**Consultation Response from KC,  
Highways Development Management****2022/91751 28, Battye Street, Dewsbury, WF13 1PH****Change of use and alterations to retail units to form 3 flats****Date Responded: 15-8-2022****Responding Officer: Mark Berry****Responding Ref: 15-2NE-49**

This application seeks approval to the change of use and alterations to retail units to form 3 flats at 28, Battye Street, Dewsbury.

GROUND FLOOR PLAN AS PROPOSED

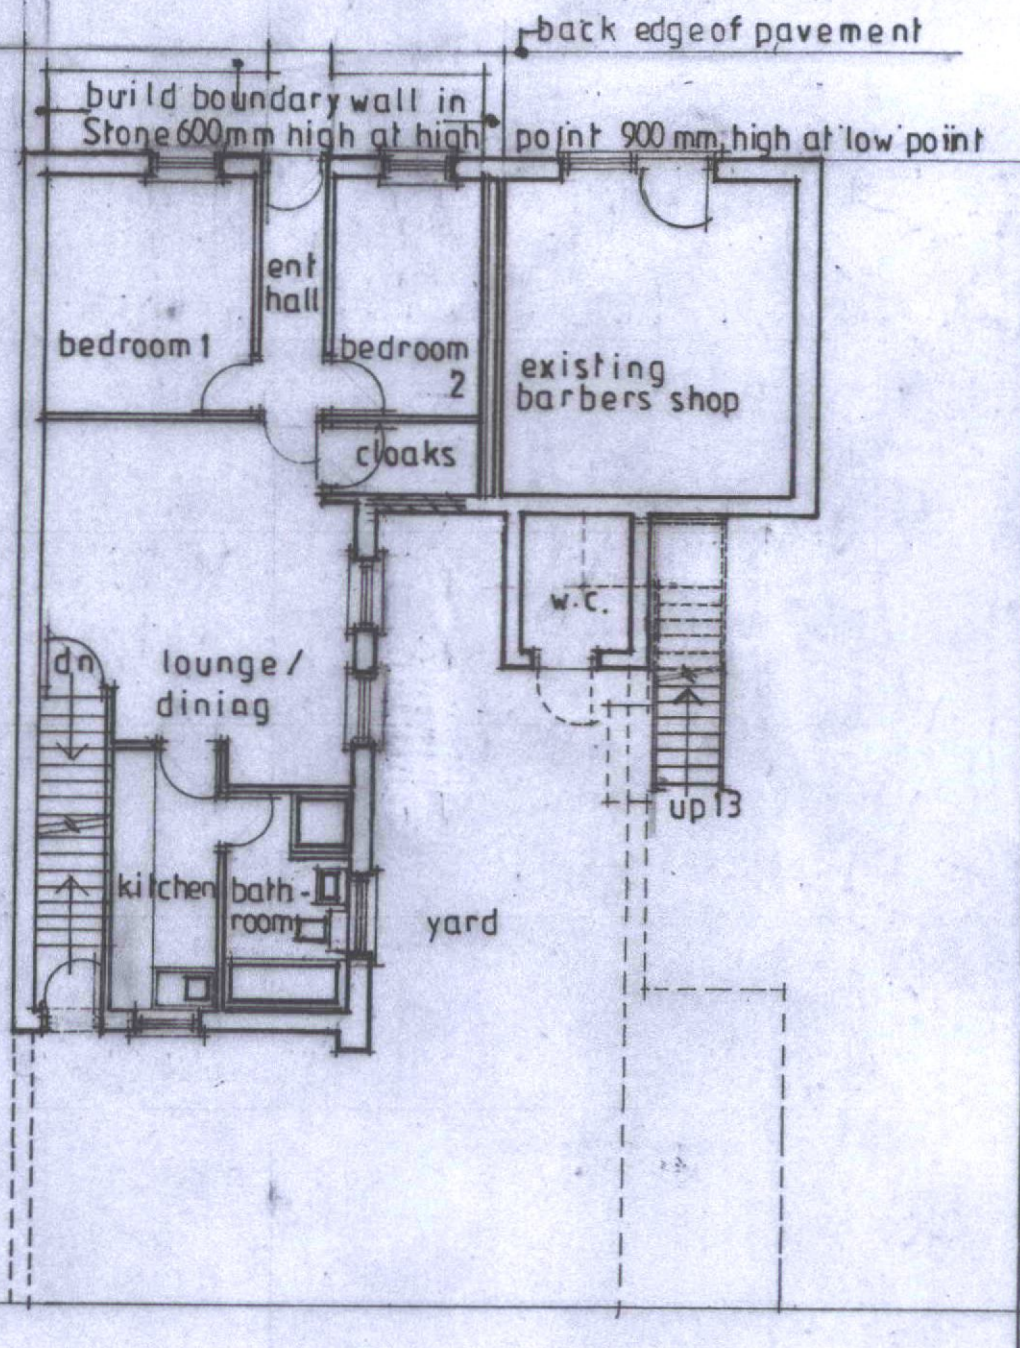
Three parking spaces are shown to the rear of the site. These spaces are poorly laid out and not all the spaces are accessible.

Given the sustainable location and the closure of the existing retail unit Highways Development Management have no objection to these proposals in principle, however the proposed parking spaces are not shown to be independent accessible parking spaces and are not considered suitable for the proposed flats.

Can the applicants be asked to clarify their intention regarding parking? Any parking spaces to be allocated to the proposed flats should be unobstructed independent spaces.

The applicants show ownership of the forecourt fronting the property, but the Council have surfaced the footway up to the face of the building. As this area has been open to public use the public may have established rights over it and it is advisable therefore that the applicants apply for a stopping up order.
